<b>Application reference number</b>	2025/0359
-------------------------------------	-----------

<b>Proposal Description:</b>	Front extension to building to enlarge the existing porch
<b>Location:</b>	Shaws Fish and Chips, Barnsley Road, Dodworth, Barnsley, S75 3JU

Recommendation: **REFUSE Planning Permission**

PLANS & ELEVATIONS

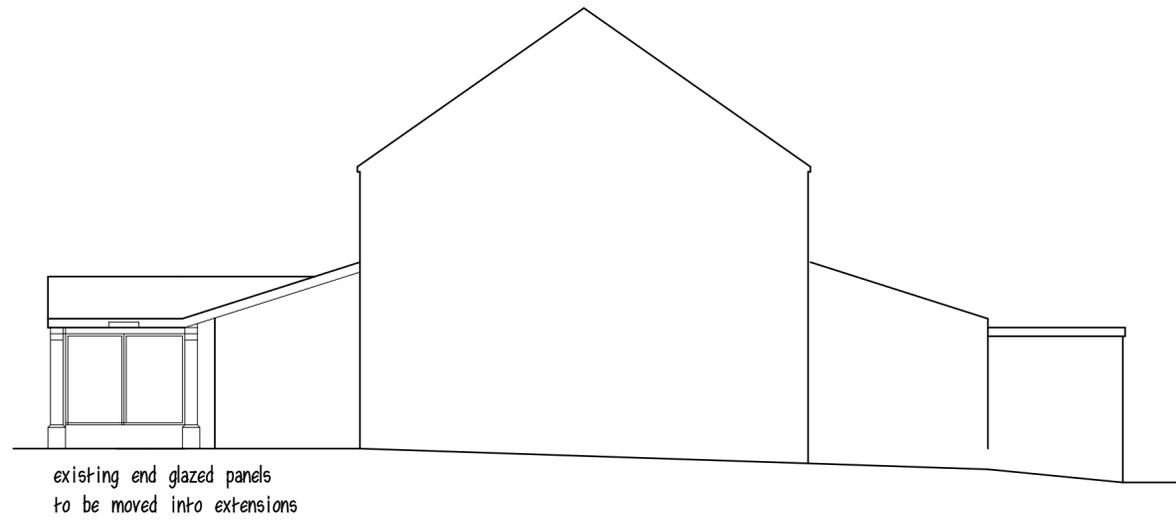
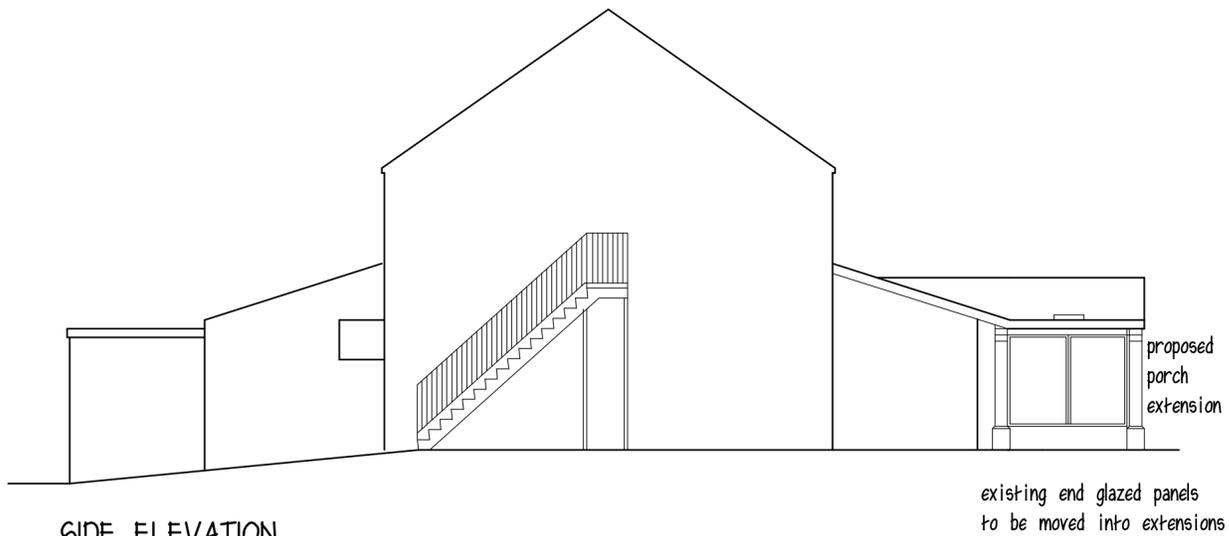
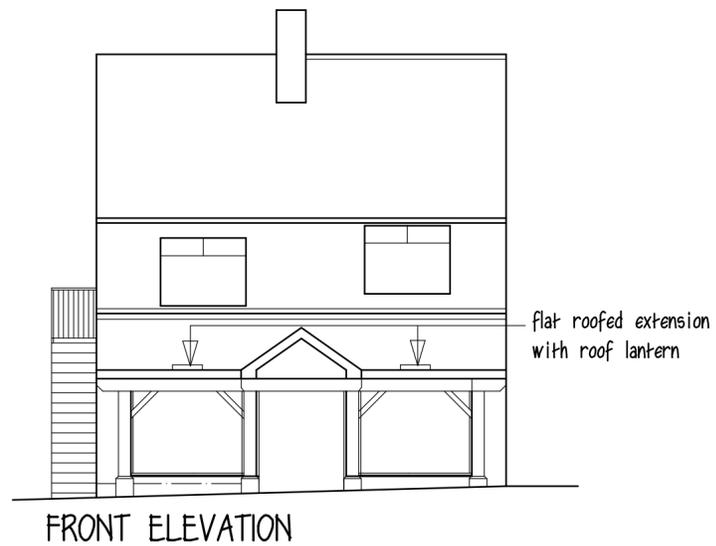
The proposed flat roof extensions are modest, designed to sit either side of the existing pitched roof porch but it is considered the extent of flat roof will still appear out of keeping with the character of the existing building and the street scene in general. Although the extensions are relatively lightweight because they are mainly glazed walls, they will have a frame to match the existing oak posts and frame on the existing front extension and porch; and will have a flat roof and plinth of unknown materials. In combination, it is considered the framing of the proposed flat roof extensions will draw attention to their form, which is out of character with the building and the street scene. Because of the relationship of the proposed extensions to the previous front extensions, it is not clear that the design of the extensions could be amended in a way that would result in acceptable form of design.

It is concluded that the proposal conflicts with Local Plan policy D1 and national planning policy which seek to secure a high standard of design. Significant weight against the proposal is given to this material consideration.
